Your Ref: OWPC17447
Our Ref: A/8/18/PL 26-01-2018
Please ask for:
Mrs D Johnson

Variation of condition 2 imposed under A/173/16/PL to read 'the development to be carried out in accordance with the following approved plans ADC 962/04 REVA, ADC962/13 & ADC962/14 relating to revised position of rooflights on east, north & south elevations. This application affects the character & appearance of the Angmering Conservation Area.

Land Rear of 1 To 6 The Cottrells Angmering

A		Layout amended		10.11.17	
Rev		Description		Date	
Job Reference		Client			
New House The Cottrells Angmering, BN16 4AF		AM Homes Ltd			
Drawing Title		Drawing No		Rev	
Ground Floor Plan		ADC962/04		A	
Date	Scale	Dwg Size	Plot Style	Drawn	Checked
24.04.17	1:100	A3	ADC-red	TGS	AD

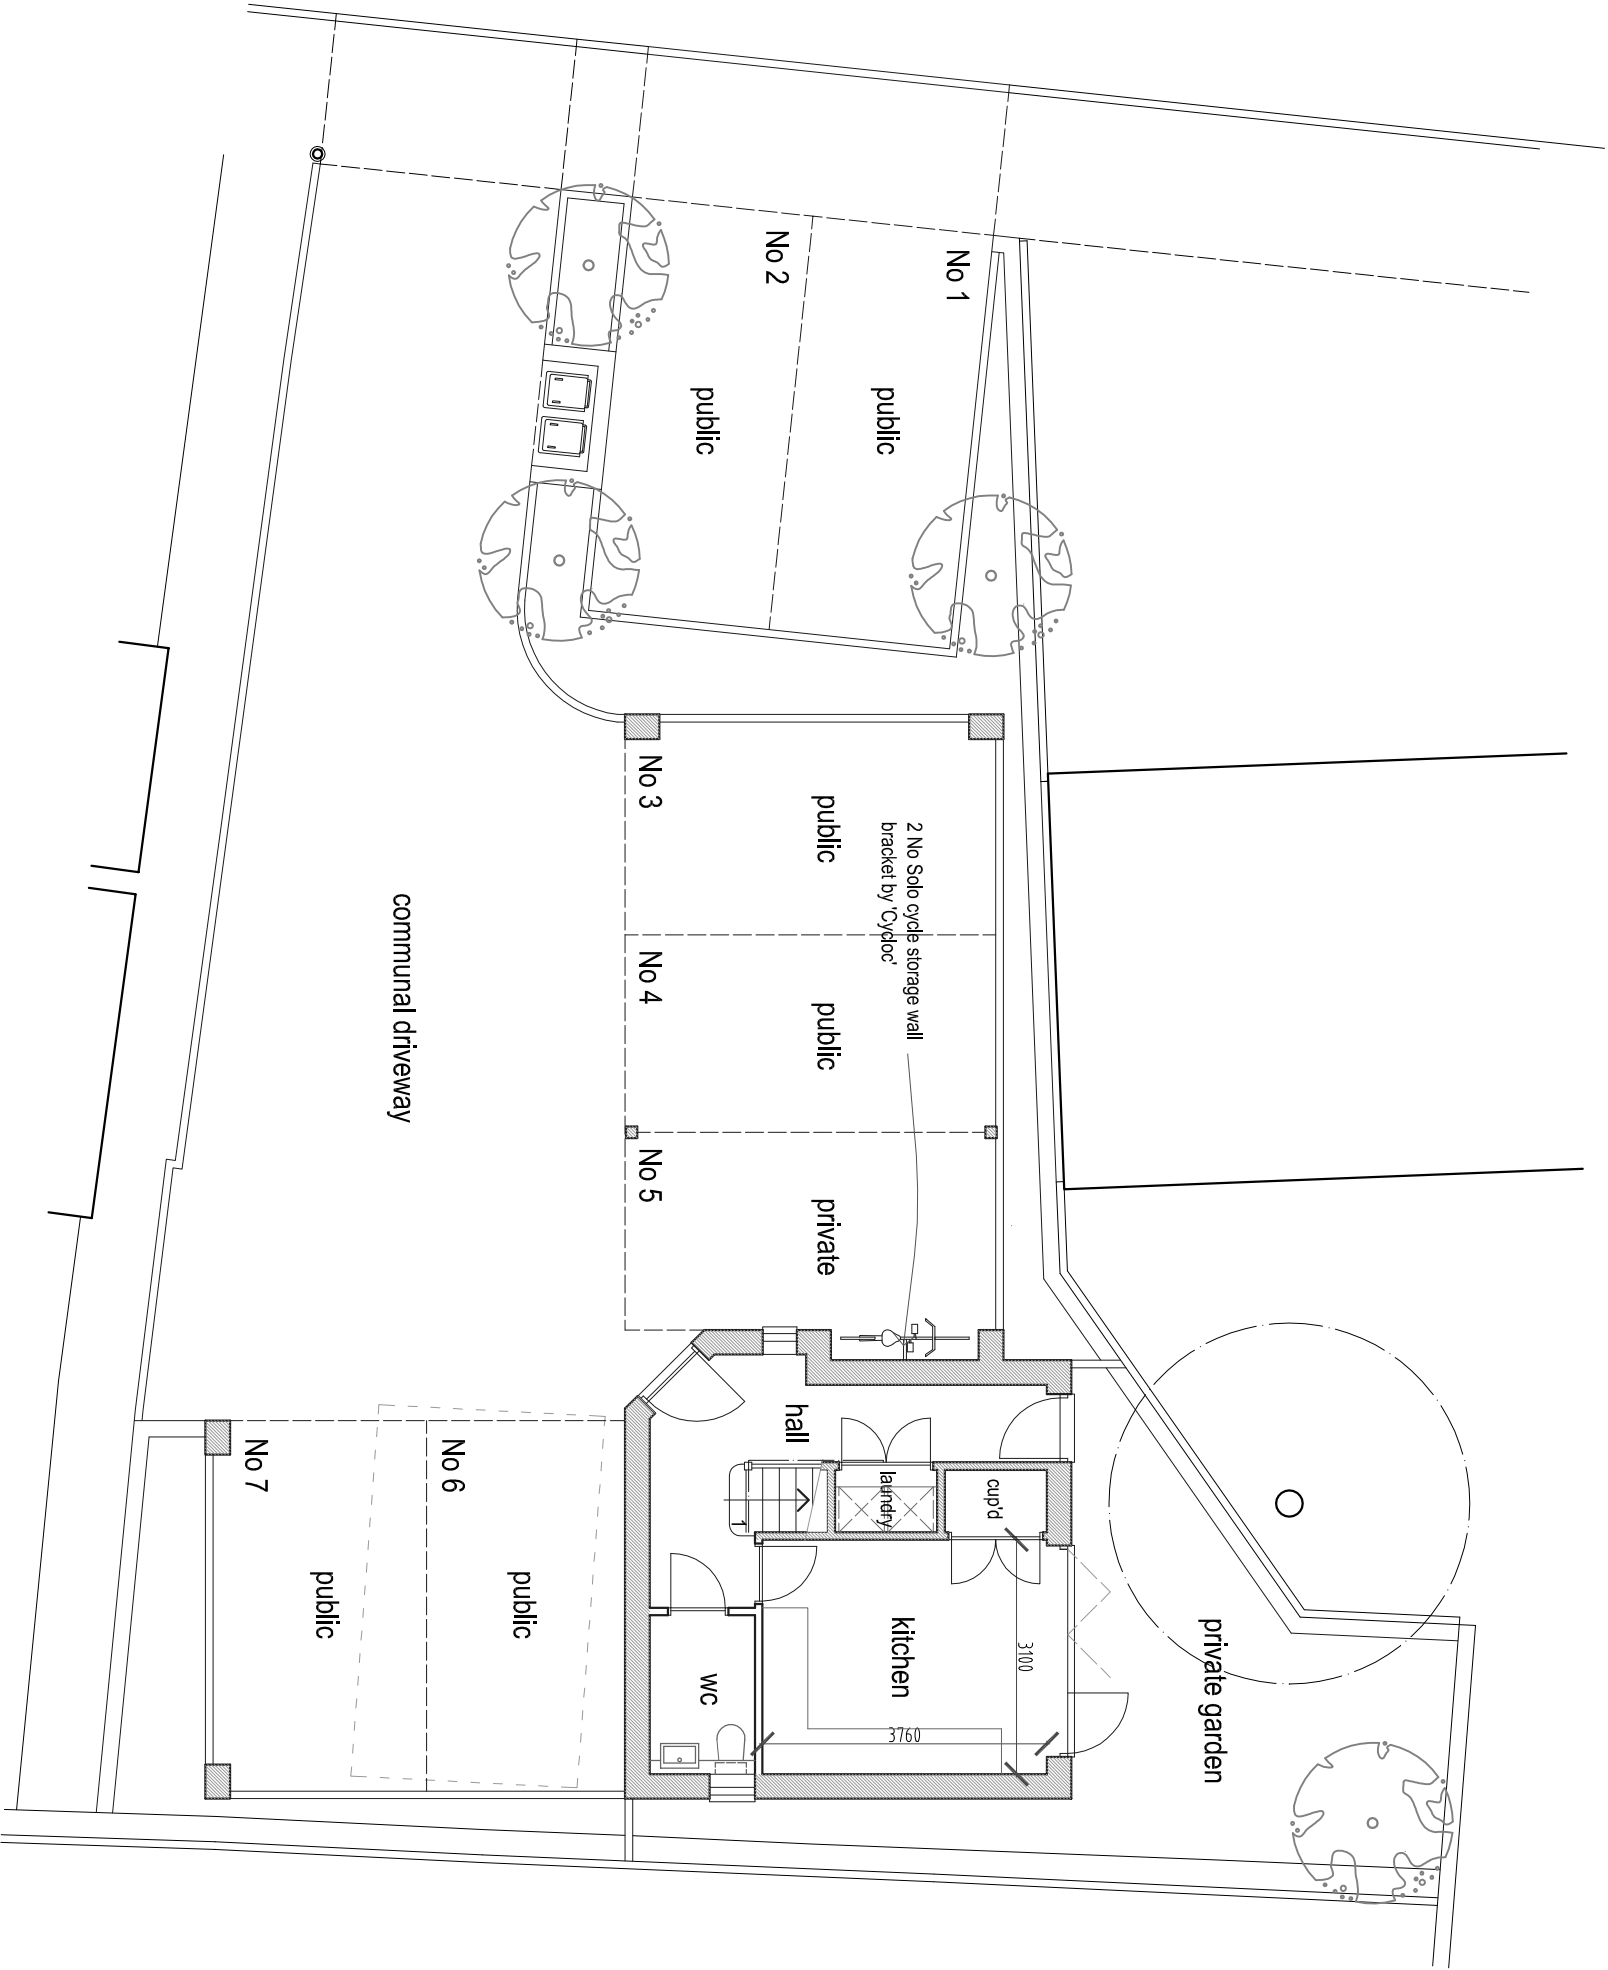
The building encroaches on the right of access alleyway behind 1-6, therefore the wall of the property is outside the plot boundary, it is also built right up to a drain cover, the concrete shoulder of which has been destroyed to allow space for this.

Rev	Description	Date
Job Reference New House The Cottrells Angmering, BN16 4AF		
Client AM Homes Ltd		
Drawing Title First Floor Plan & Roof Plan		Drawing No ADC962/13
Date 16.01.18	Scale 1:100	Dwg Size A3
		Plot Style ADgrey.spl
		Drawn AD
		Checked AD

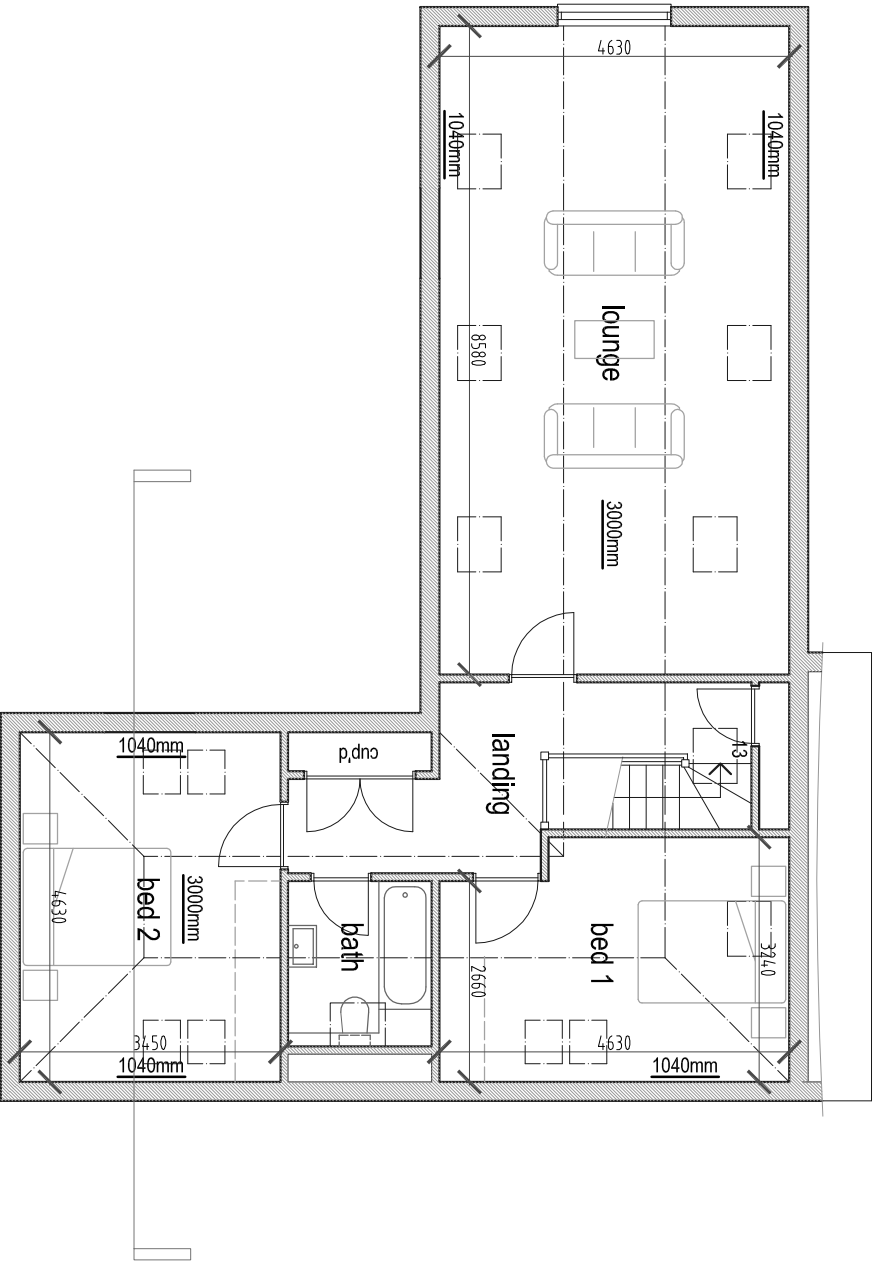
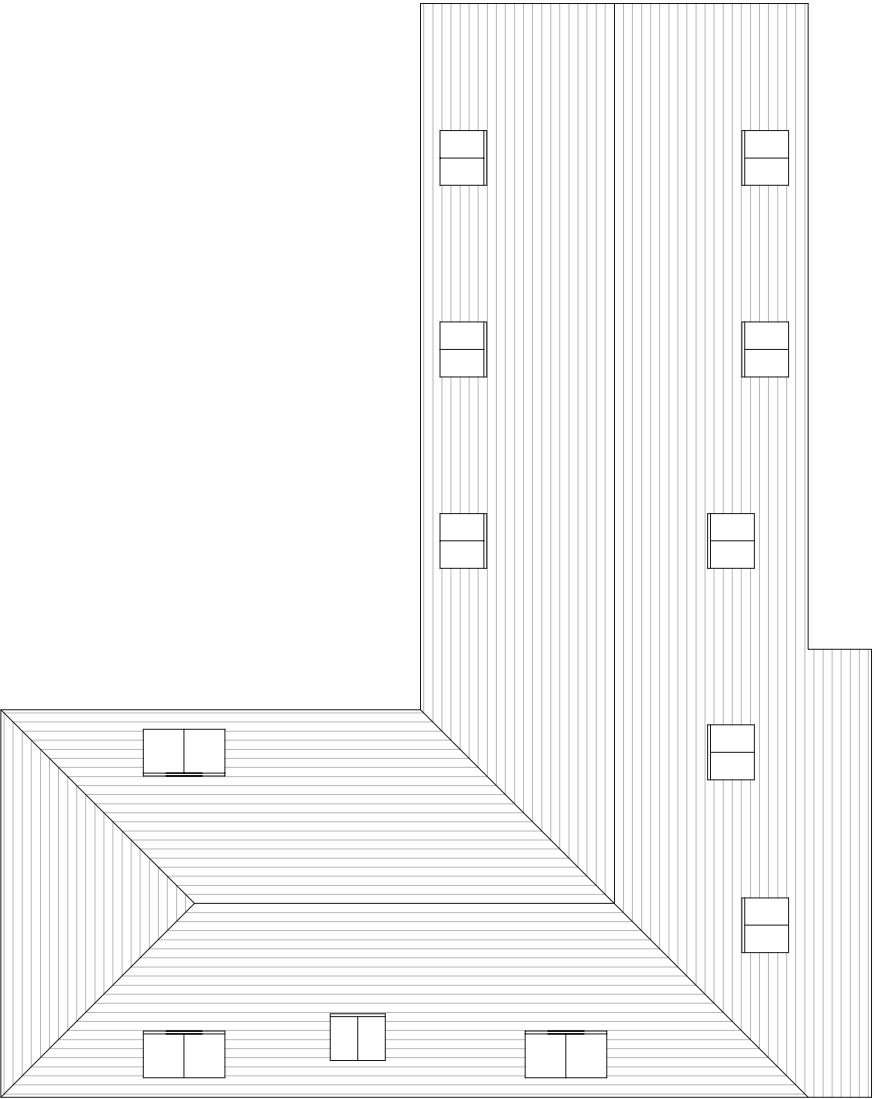
It seems that the interior layout has been planned and built to allow for a third bedroom, permission for which has not been granted.

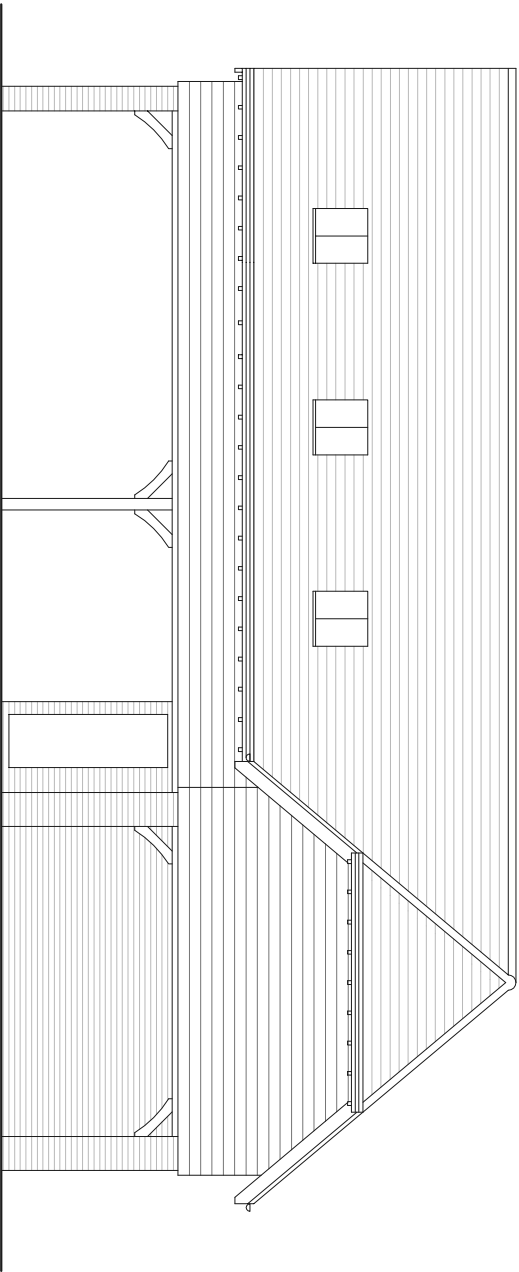
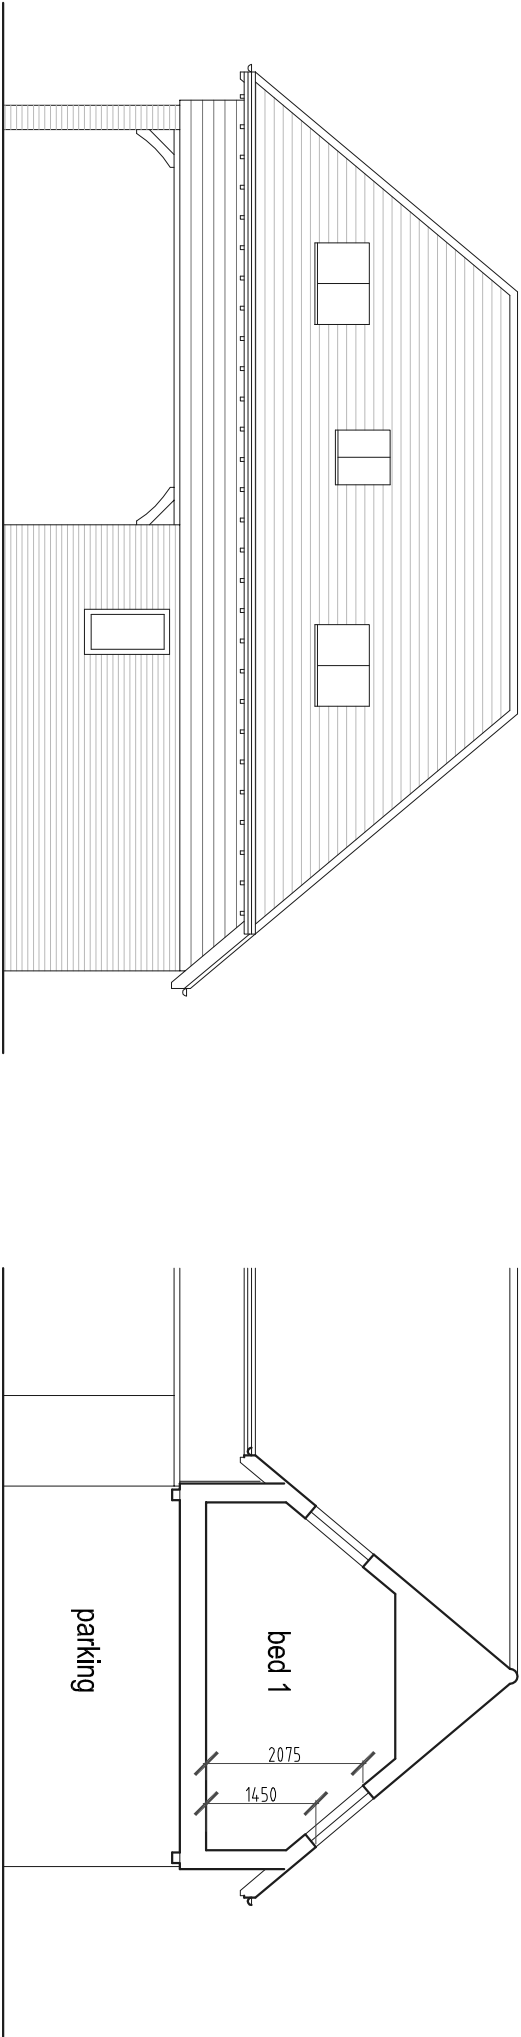
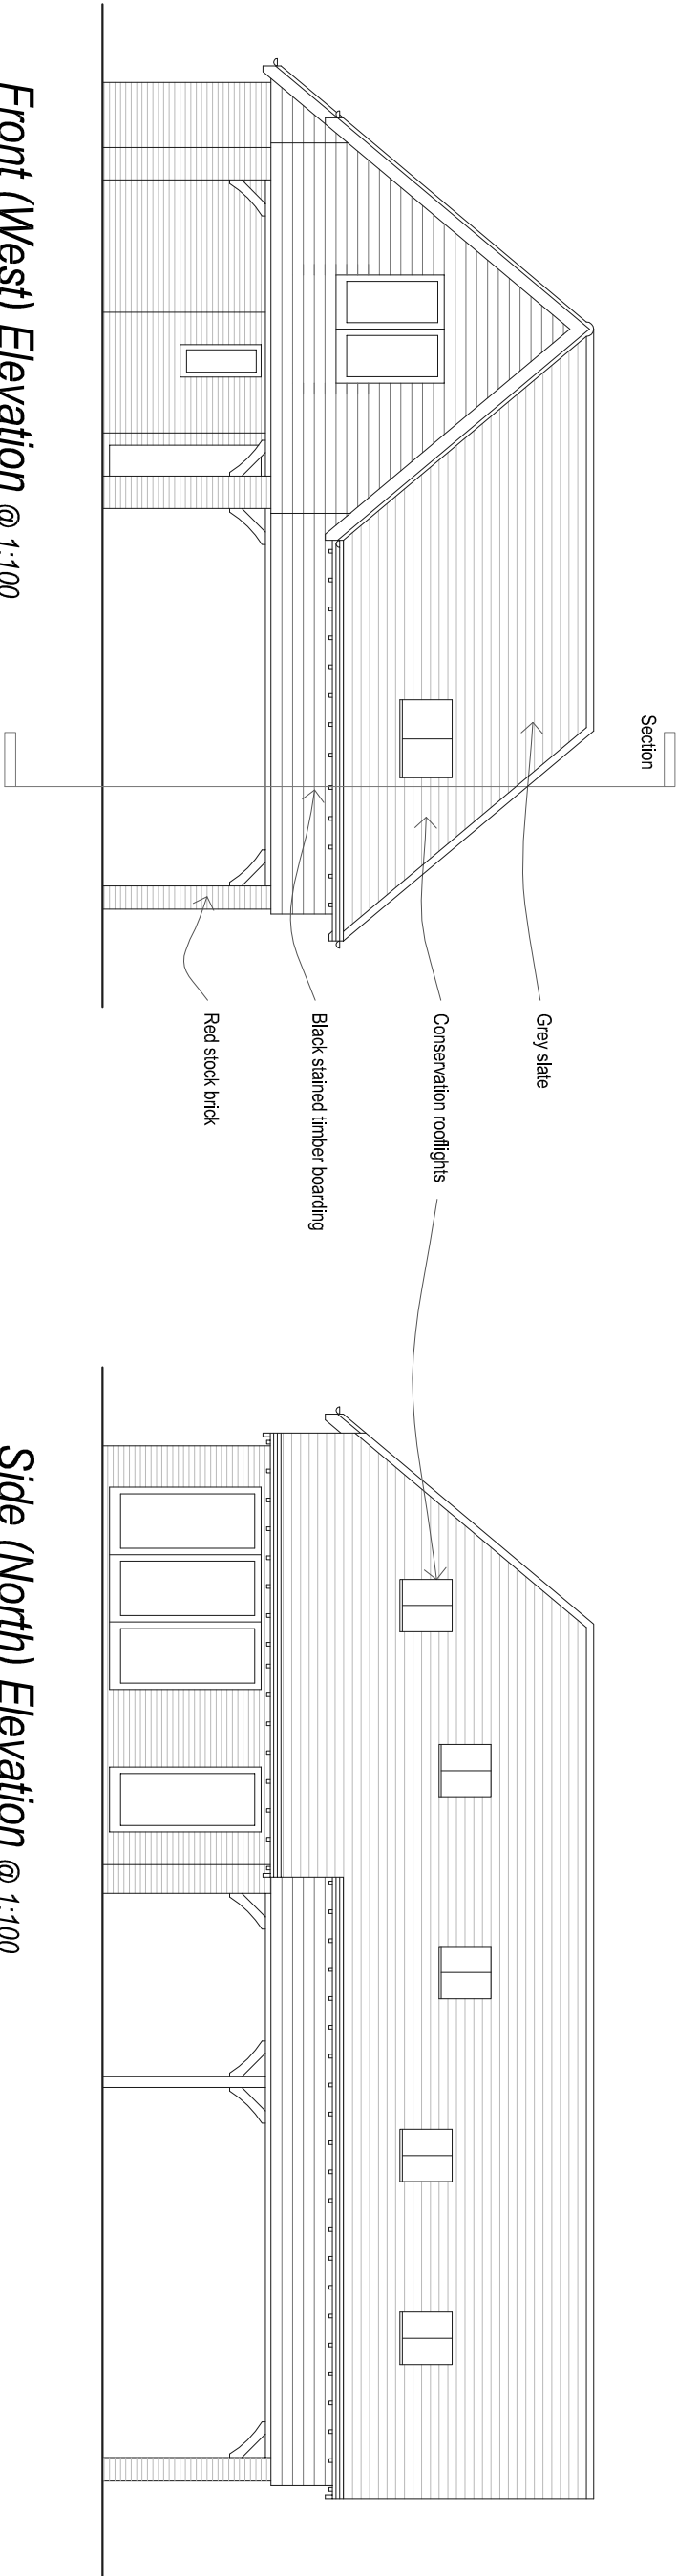
The constructed roof line on the south elevation differs from the approved plans being a barn end instead of the approved hip end. This results in the houses and gardens of houses 1-6 being even more overlooked.

It also results in the development becoming even more intrusive and at odds with the surrounding conservation area.
